Minutes

Purpose: Summary of Consultation Meeting Between Ku-ring-gai Municipal Council Representatives & the Project Team for the Roseville College Student Wellness (SWELL) Centre Development (the proposed development)

Application Number: State Significant Development (SSD) – Ref: SSD-9912

Sheet: EPM05-DA-101

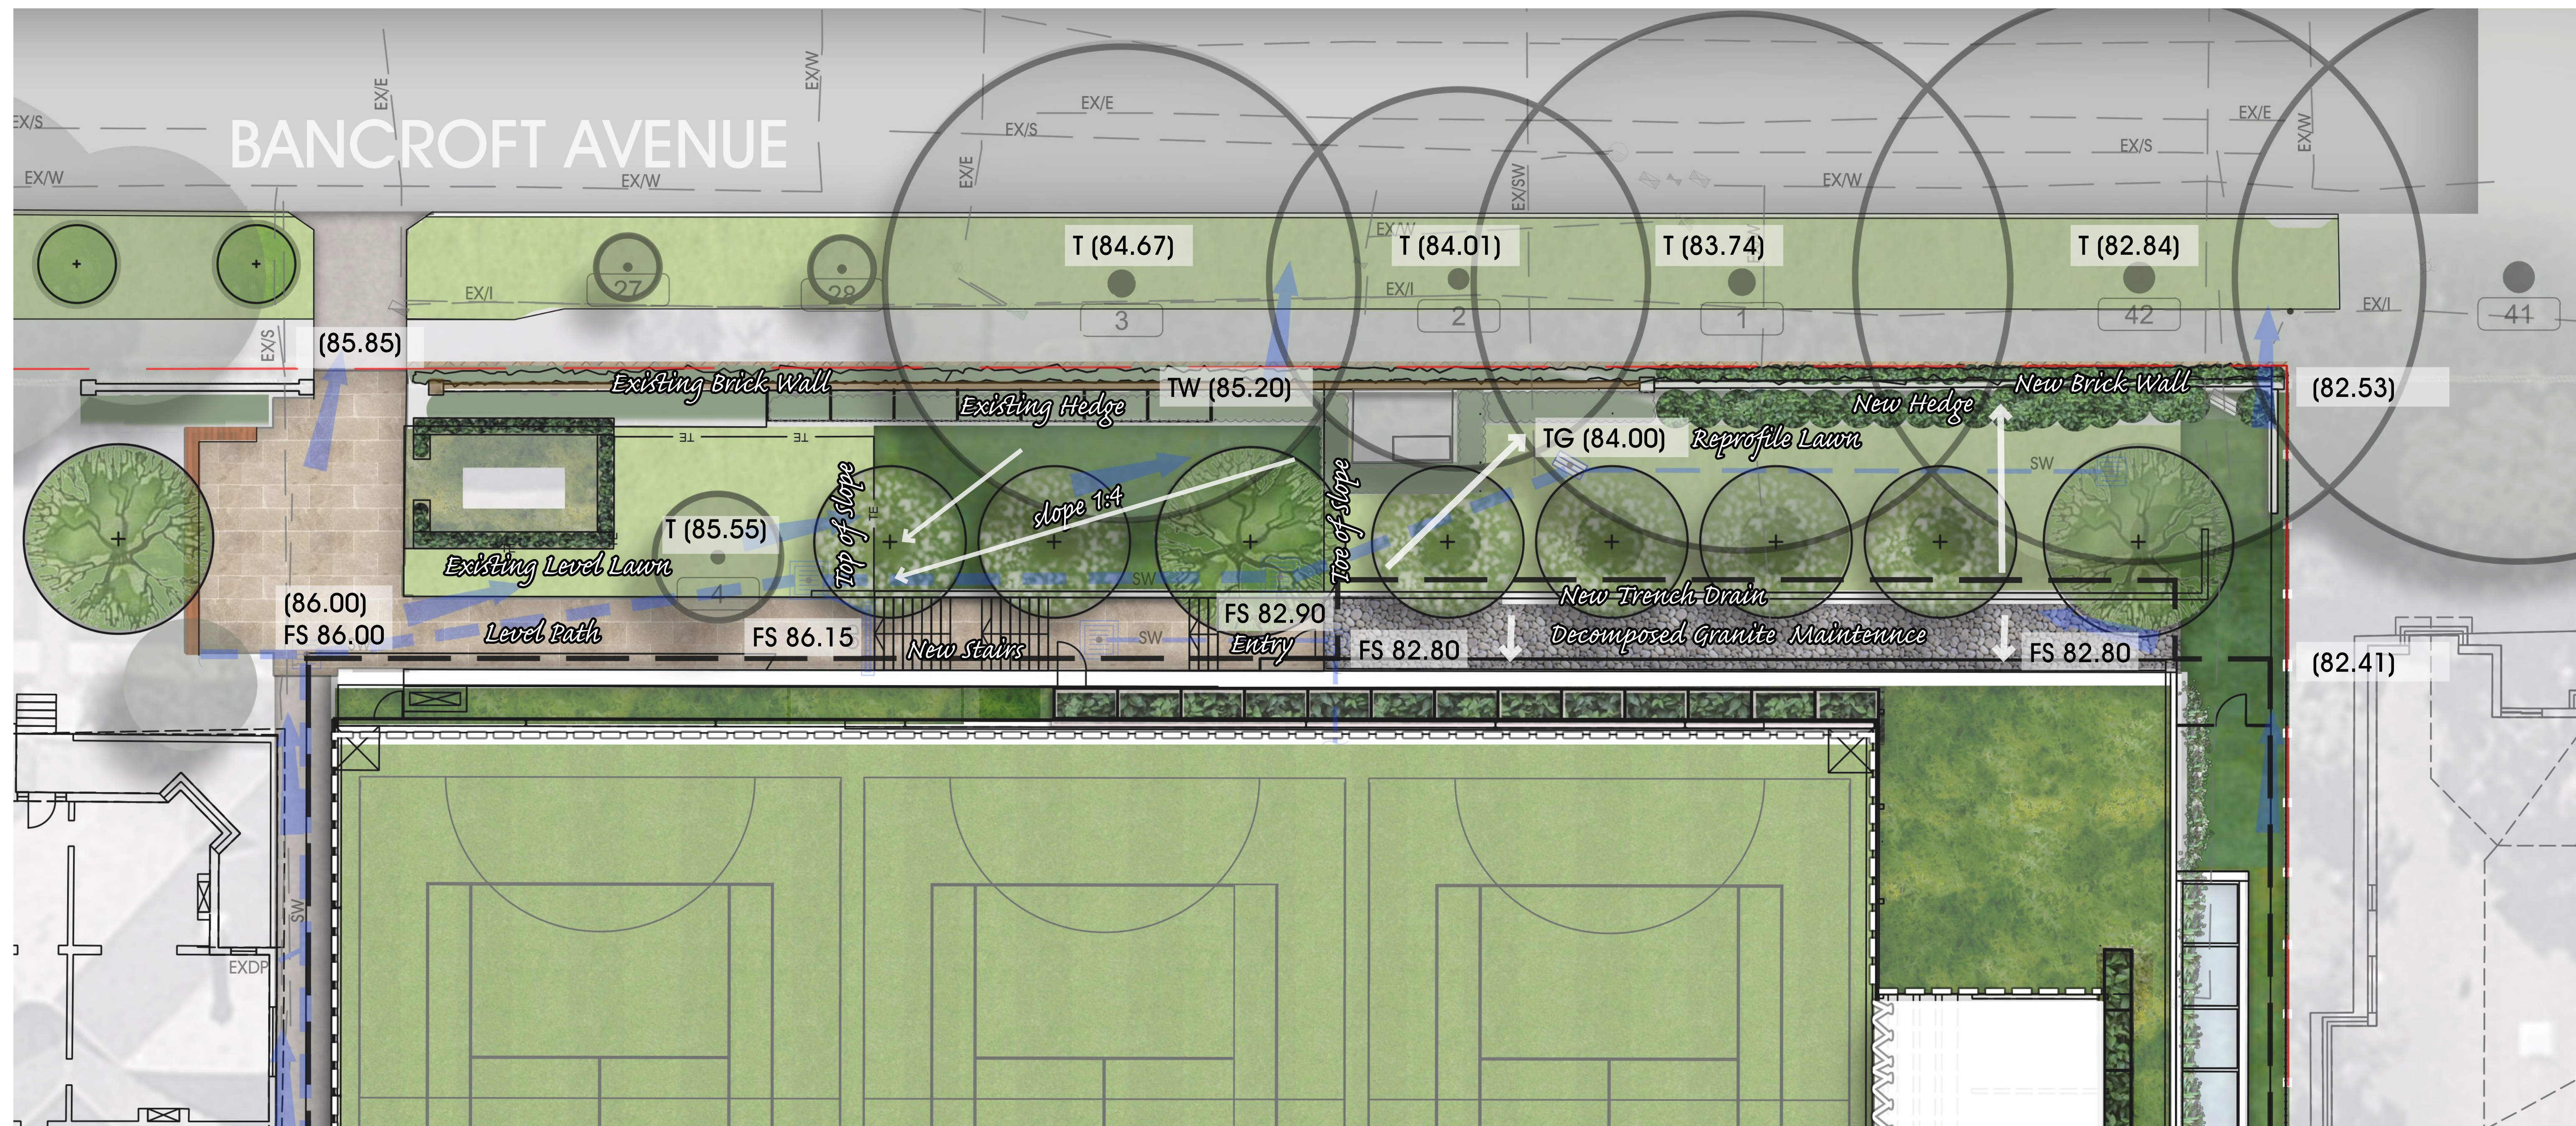
- Selwyn Segall invited Geoff Bird, Senior Development Officer – Landscape & Ecological Assessment to provide comments in relation to the project's Landscape elements first. Below is a summary of the comments provided:
 - The removal of tree No. 7 (Himalayan cedar) is not supported;
 - Reliance on green walls to create landscaped elements are generally not supported. They are not common in the KMC Local Government Area (LGA). Whilst Council does not have a policy on green walls, the observation is that they tend to be removed from developments after time. Suggest deleting and consider an option with less maintenance requirements;
 - Terraced walls along Bancroft frontage are not preferred since they change the existing grading condition. It would be preferable to maintain existing grades as much as possible;
 - Eastern setback – greater tree planting rather than green walls

- Compatibility of drainage infrastructure and landscaping and in the eastern setback to be considered;
 - Usually require a 3m minimum side setback with landscape element of varying heights;
 - Exotic species for plantings preferred, to be consistent with the use of the site as a school;
 - Consider breaking down the formality of the landscaping;
 - Landscaping to provide filtering views from 39 Bancroft Avenue;
 - Setback should consist of deep soil, the inclusion of planters on structure (while not preferred) would be taken into consideration. Adequate root volume would need to be considered.
- Conrad Grayson mentioned at this time also that during community consultation the owners of 39 Bancroft expressed that they would not like to see large trees along the boundary which may overshadow their land.

- 39 Bancroft avenue is also located in a HCA. Council would ordinarily require a 12m setback to 39 Bancroft Avenue with reductions only where stepping etc justifies it. Consider more separation adjacent to the dwelling on 39 Bancroft;

- Consider reorienting the proposed pool to achieve greater separation;
 - With materials proposed, can see the design is trying to address the character of the area and be sympathetic, building still quite contemporary; and

- Agree with Landscaping comments – a landscape buffer between the proposal and 39 Bancroft
- Alida Eiserman at this time mentioned that UH's assessment of 37 Bancroft Avenue being demolished and the development in general was supportable.

- ***Separation** of the proposed building from the neighbouring house at No. 39 Bancroft is important. See Council's Heritage Controls 19F.2 **Building Setbacks** The proposed pool is located fairly close to the side boundary of No. 39. Consideration of Council's Heritage Controls 19F.2 **Building Setbacks** should be considered. Further setback especially near the house is necessary.*

- *Formal street **planting** is not appropriate in the vicinity of an HCA. Consideration of Council's Heritage Controls 19F.3 **Gardens and Landscaping** should be considered as planting should be informal.*
